**KIRKLEES METROPOLITAN COUNCIL
INVESTMENT & REGENERATION SERVICE**

**DELEGATED DECISION TO DETERMINE APPLICATIONS FOR
CONSENT, AGREEMENT OR APPROVAL REQUIRED BY CONDITION**

Reference No:	2024/44/93077/E
Site Address:	Dunkirk Inn, 231, Barnsley Road, Lower Denby, Huddersfield, HD8 8TX
Description:	Discharge details reserved by conditions 15 (waste/recycling facilities), 16 (charging electric vehicles), 17 (landscaping), 18 (residential amenity) on previous permission 2020/91601 for change of use from agricultural land to Sui generis Drinking Establishment (previously A4) and erection of extensions and alterations
Recommending Officer:	Elenya Jackson

Drawing DC02
 External Landscaping Works and Residential
 Amenity Protection Measures
 at
 The Dunkirk Inn, 231 Barnsley Road, HD8 8TX

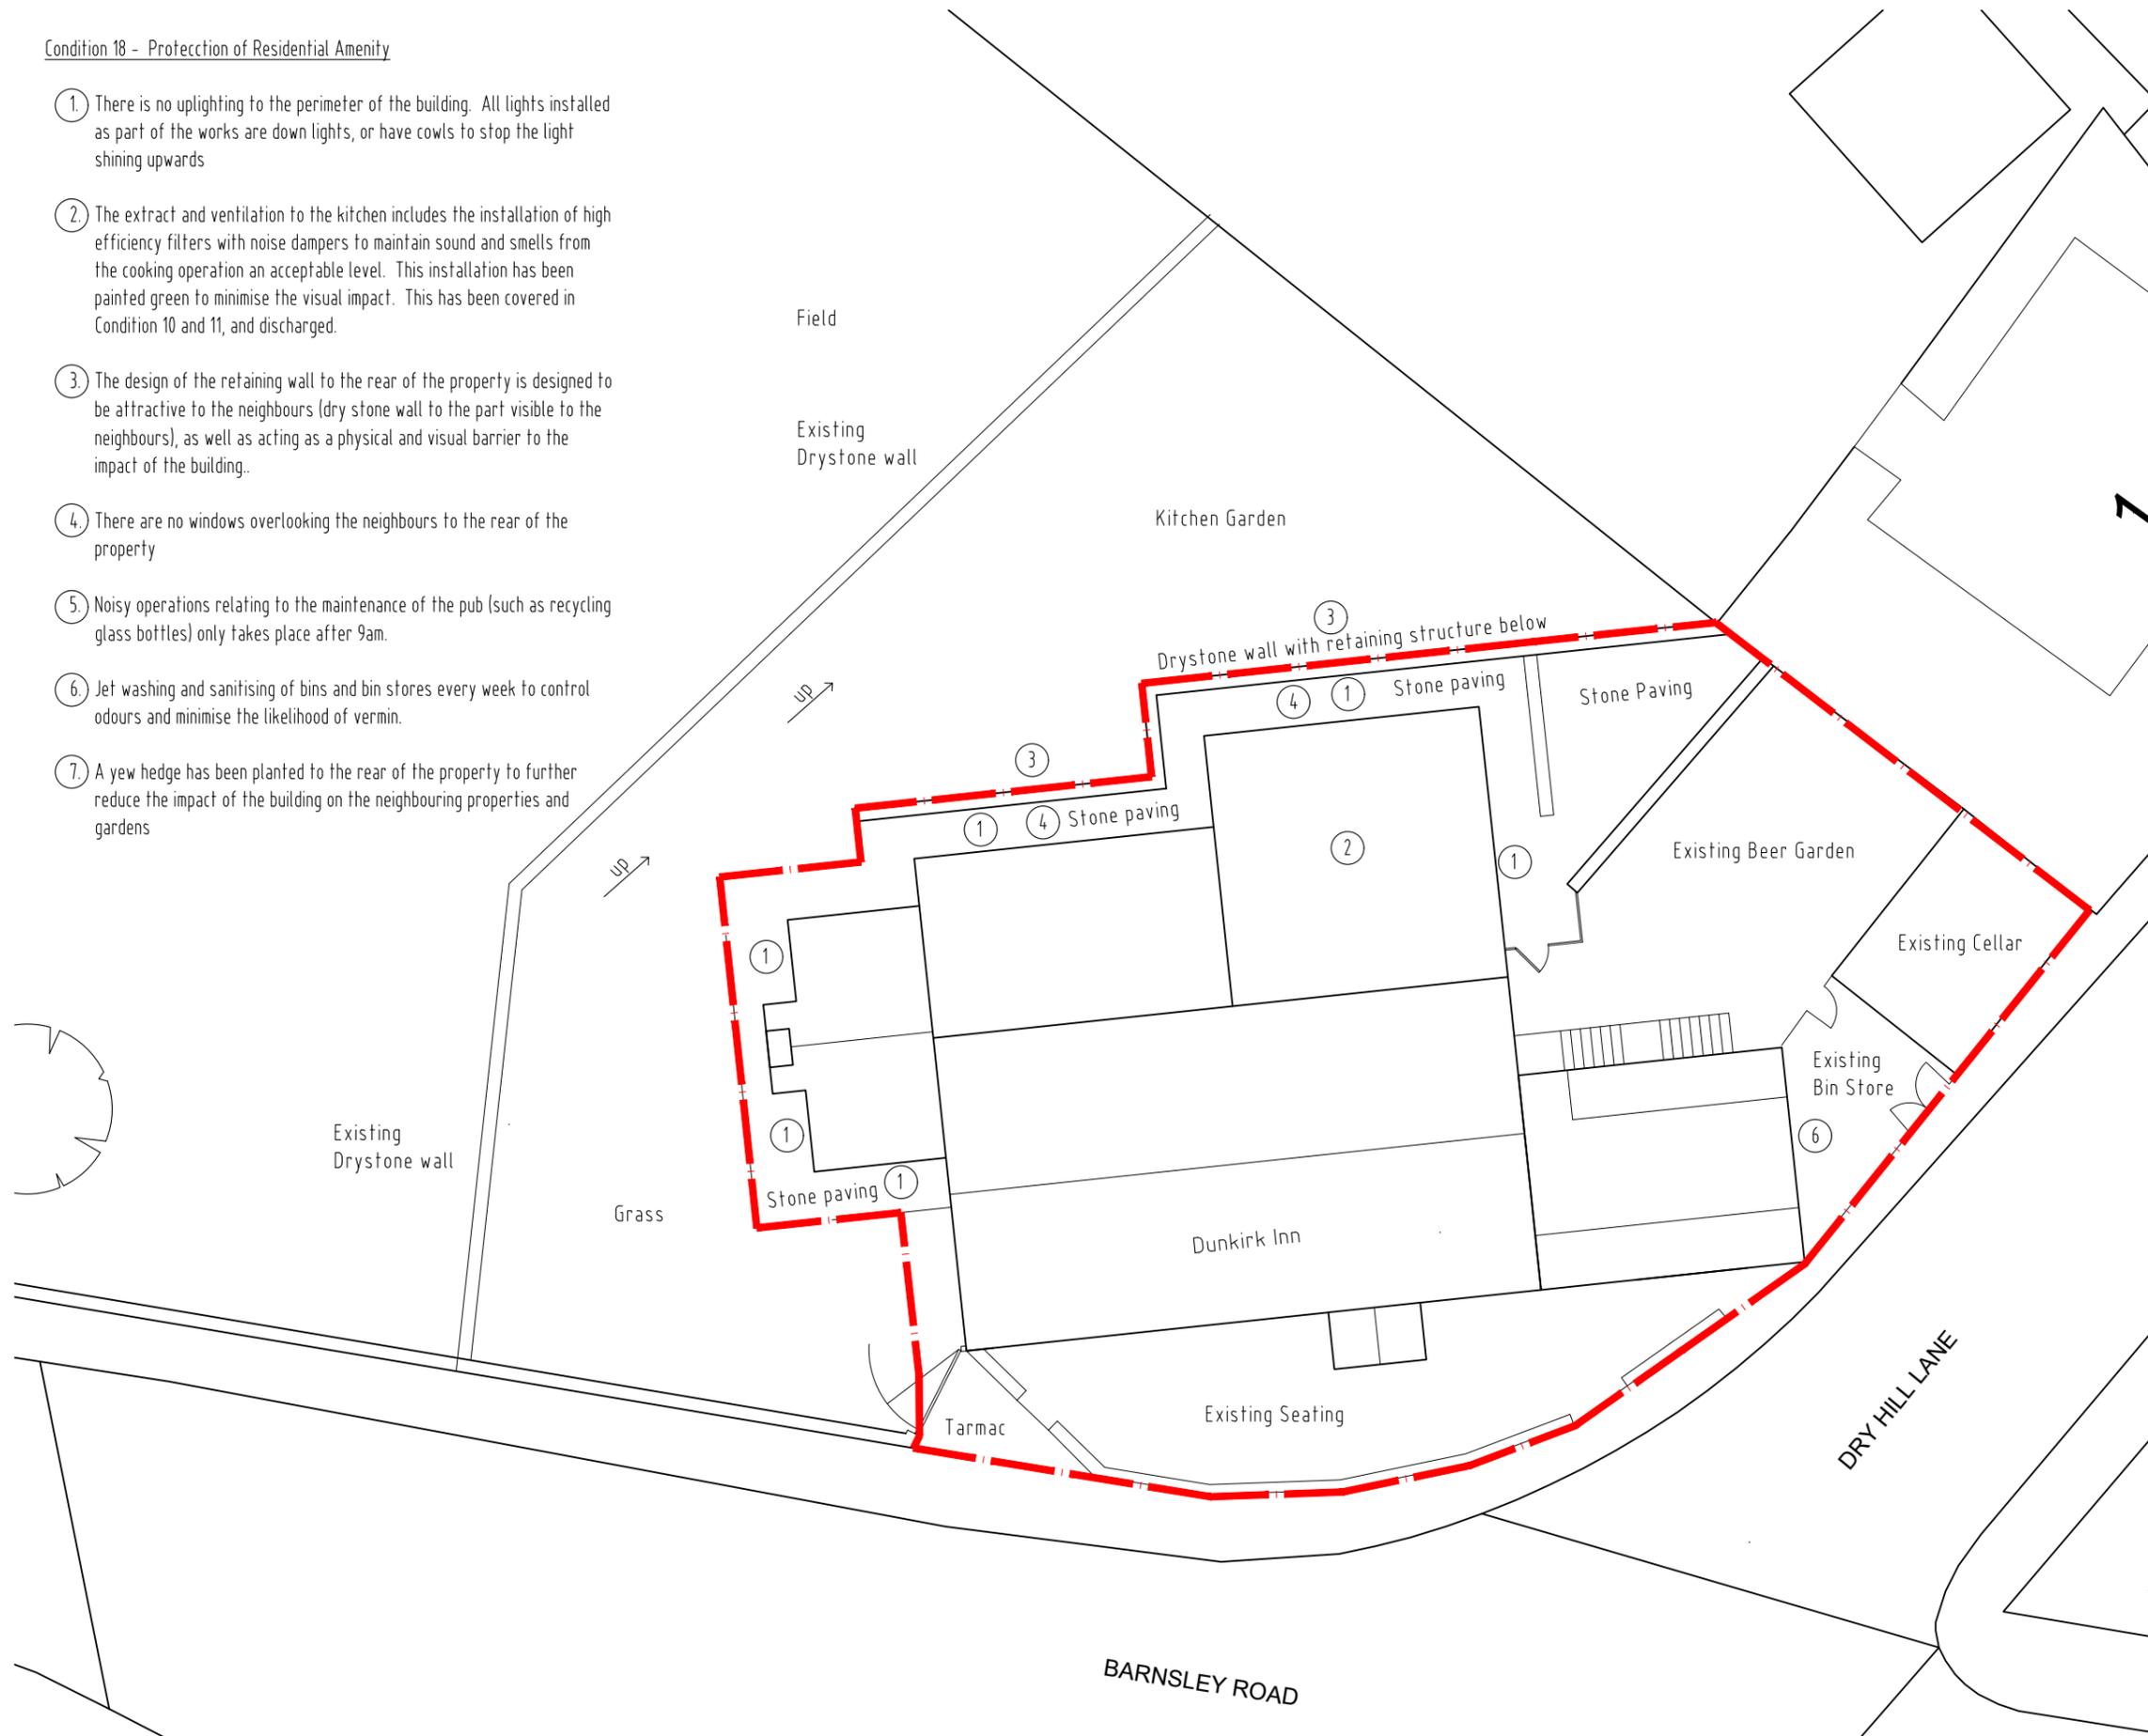
The details provided have been reviewed with KC Environmental Health and are considered acceptable

Drawing DC01  
Electrical Vehicle Charging and Recycling Facilities  
at  
The Dunkirk Inn, 231 Barnsley Road, HD8 8TX

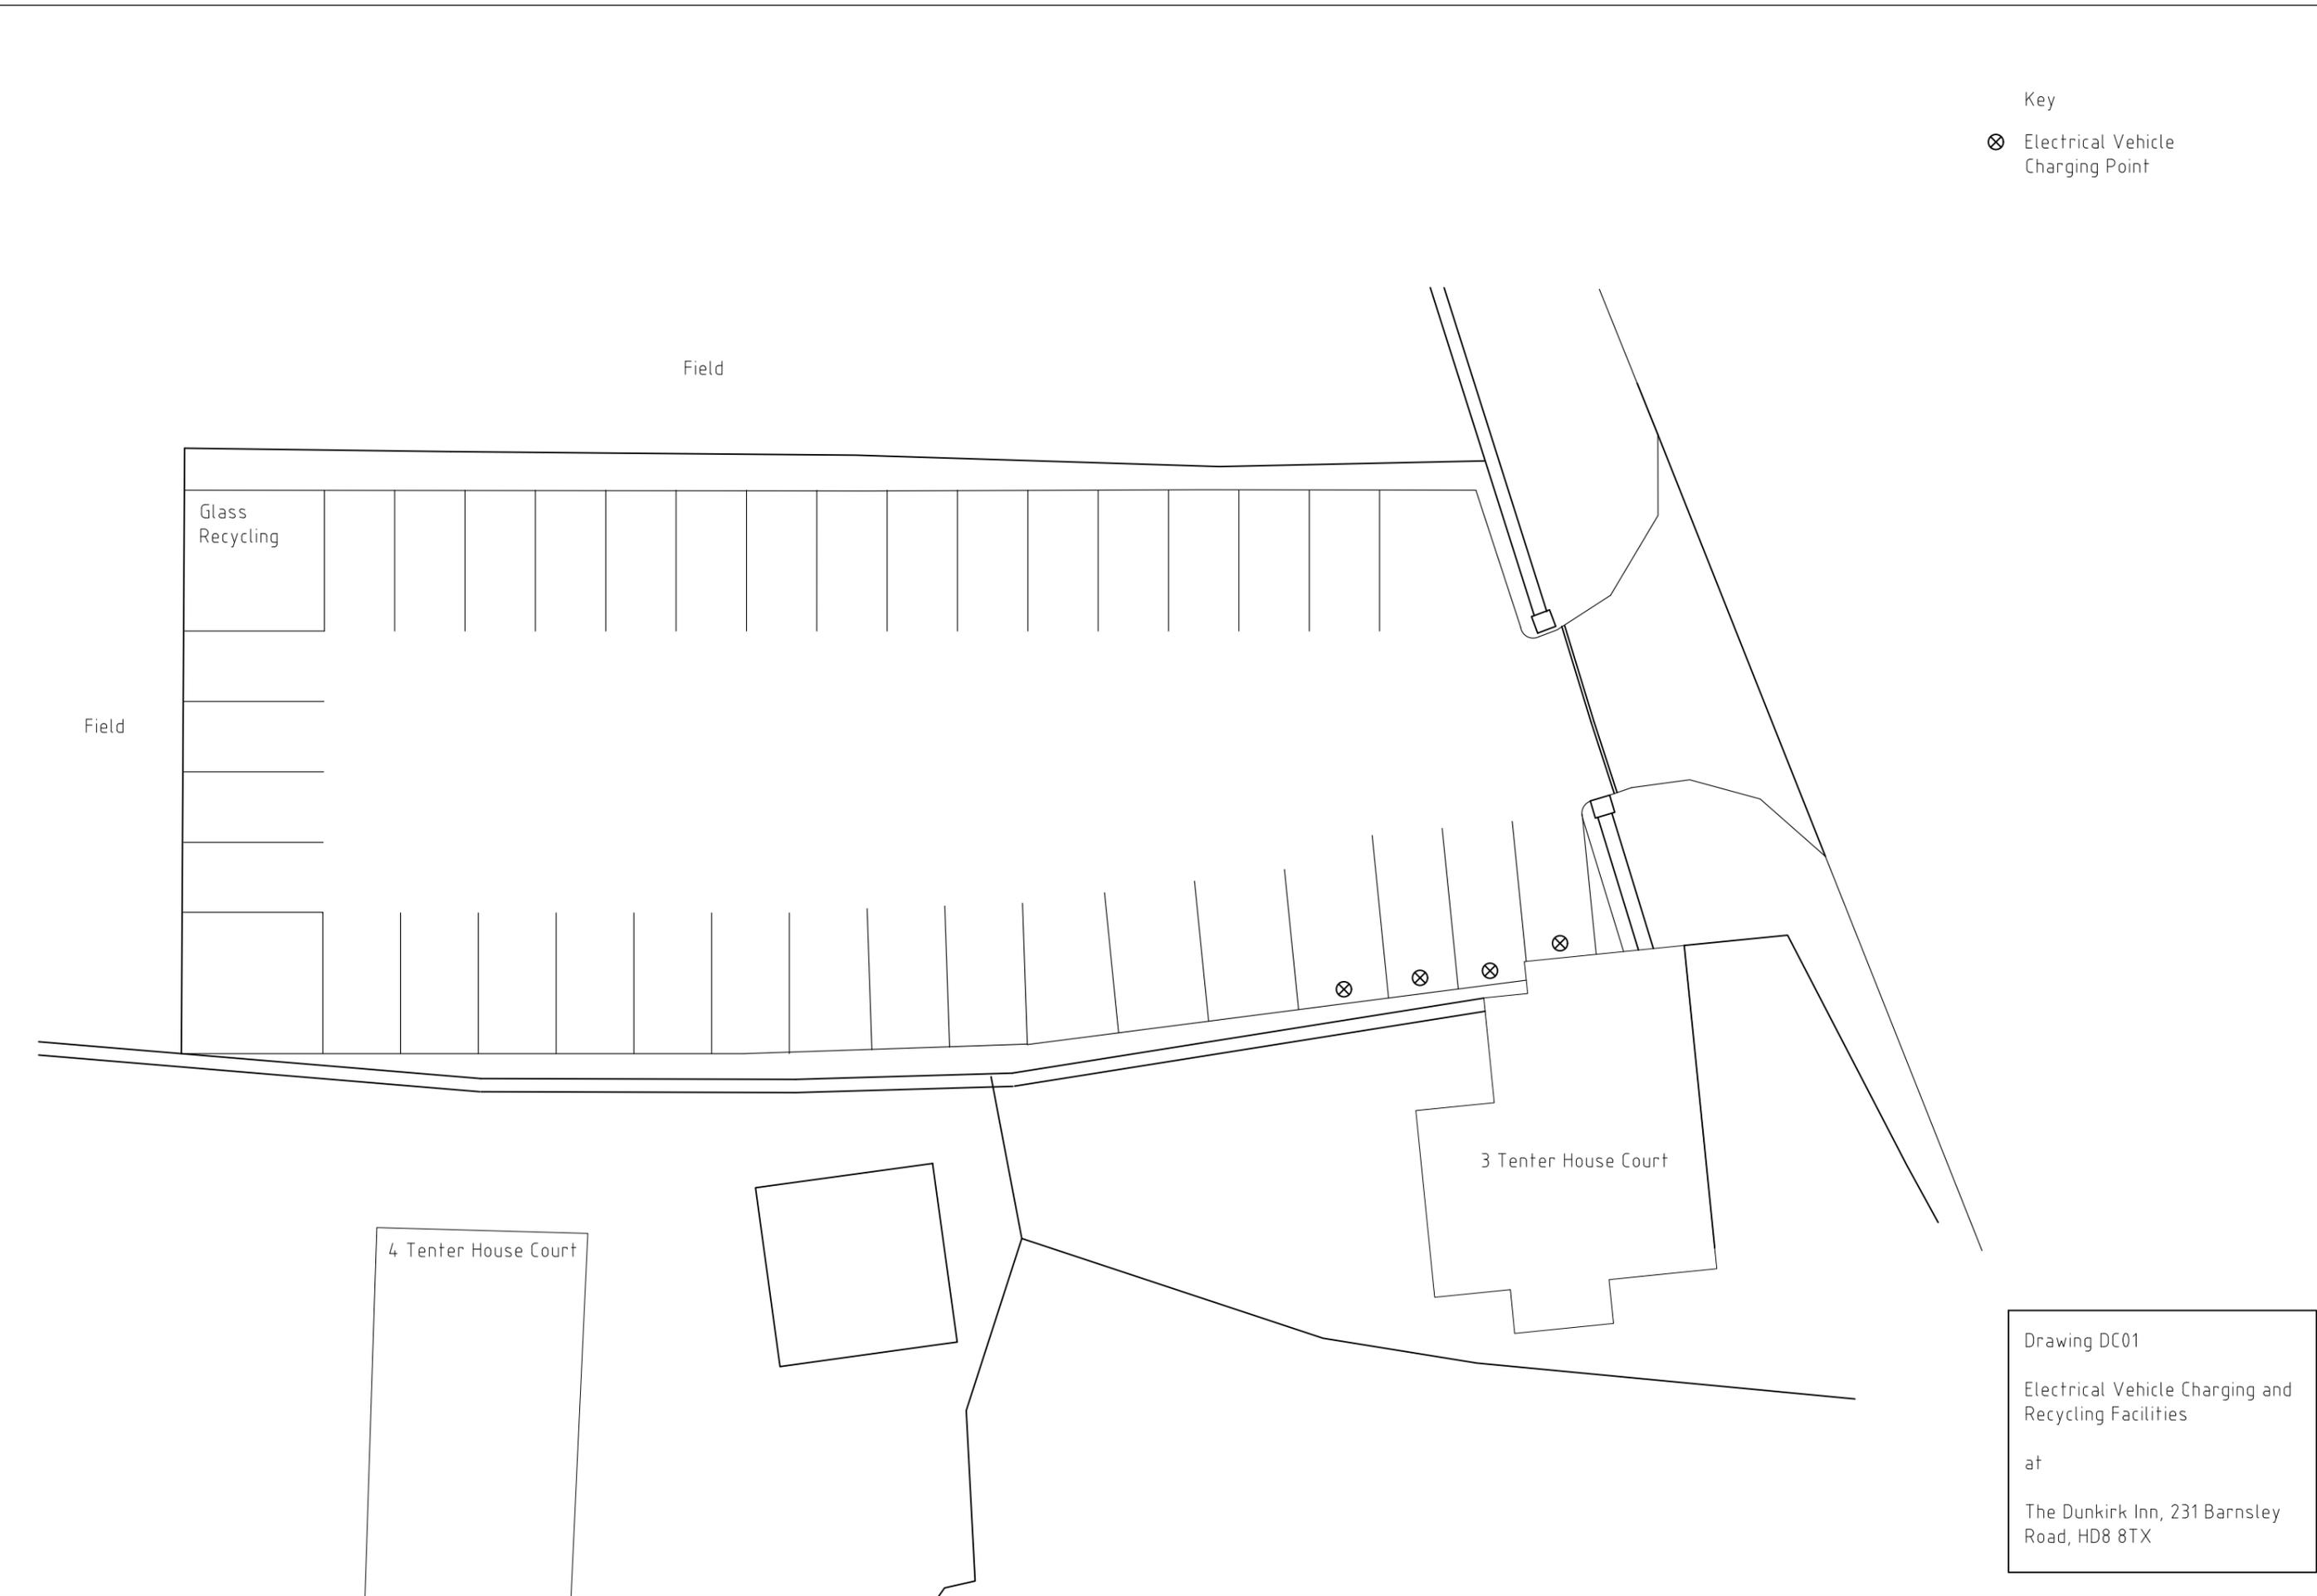
KC Highways have been consulted on the above application and have confirmed that the details are acceptable for the purpose of condition 15.

The submitted drawings indicate four electric charging points would be installed in the car park of the site,

The applicant is reminded that the electric charging points are to be retained for the lifetime of the development.
